Town and Country Planning Act 1990 (As amended)
Town and Country Planning (General Permitted development) Order 2015 Schedule 2 Part 1
Class A
Application for Prior Notification for a householder extension

Development Notification under extended permitted development rights for a single storey rear extension extending 7.95m beyond the rear wall of the dwelling house, with a maximum height of 4.45m & an eaves height of 2.49m.

Location Tig Aluinn Hook Lane Aldingbourne

DWG NO
768/05
REV. A

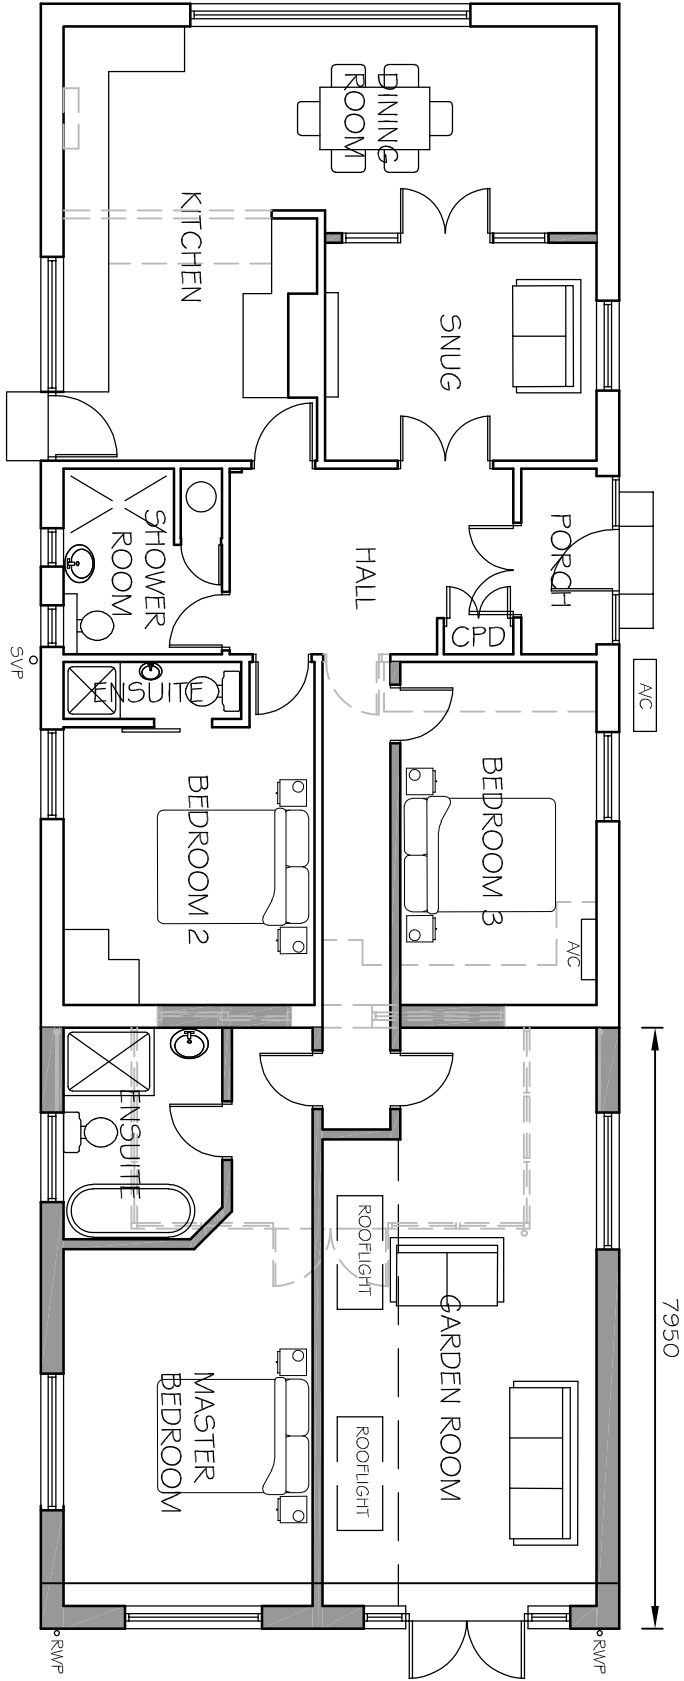
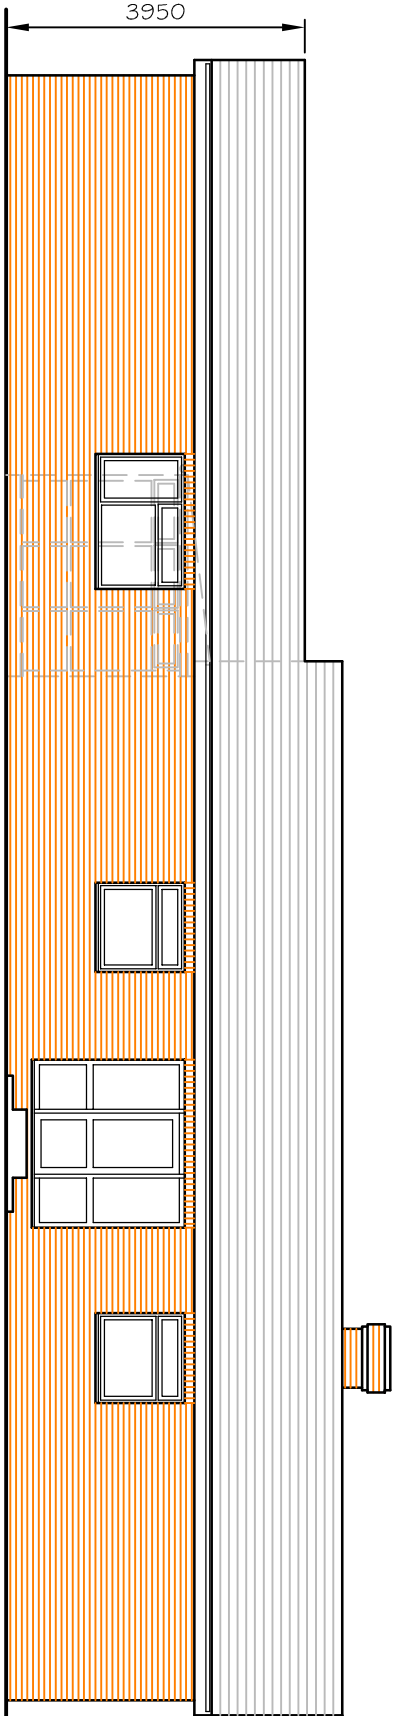
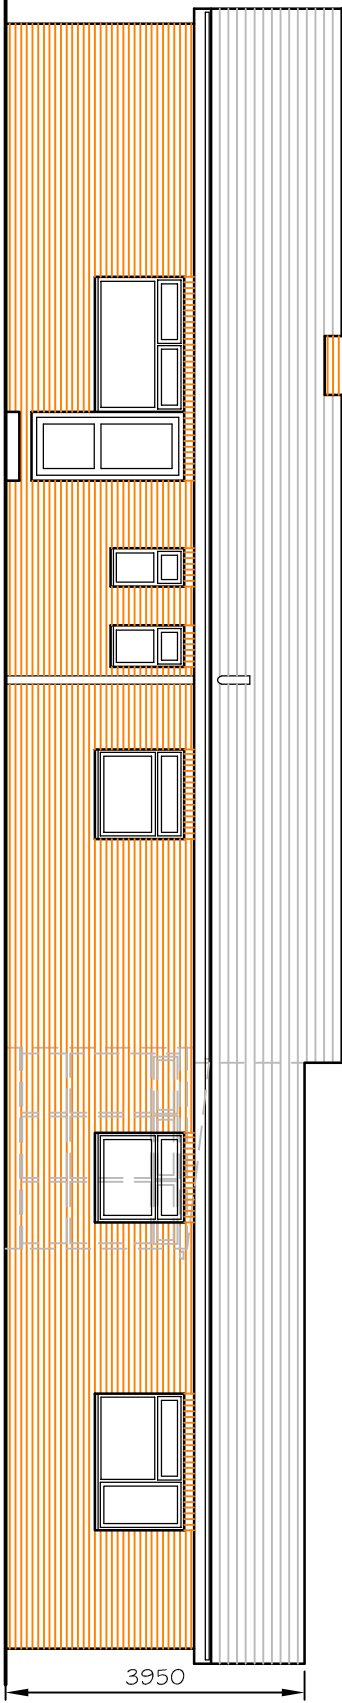
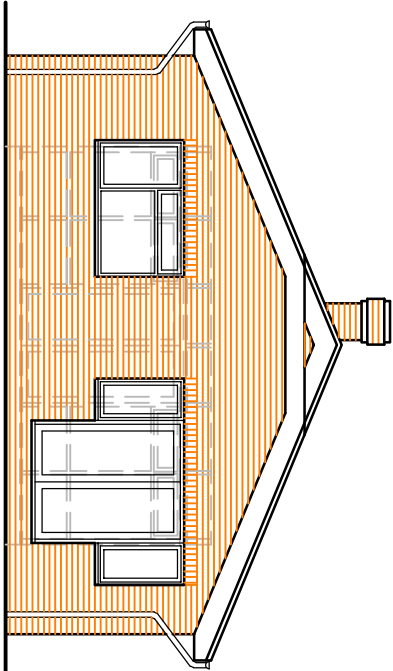
Because the proposed extension exceeds 4m in height (4.45m) (Schedule 2, Part 1, Class A, A.1.(g) (ii)) a Notification for Prior Approval for a Proposed Larger Home Extension can't be processed. Please either amend the height of the proposed extension or withdraw the application.
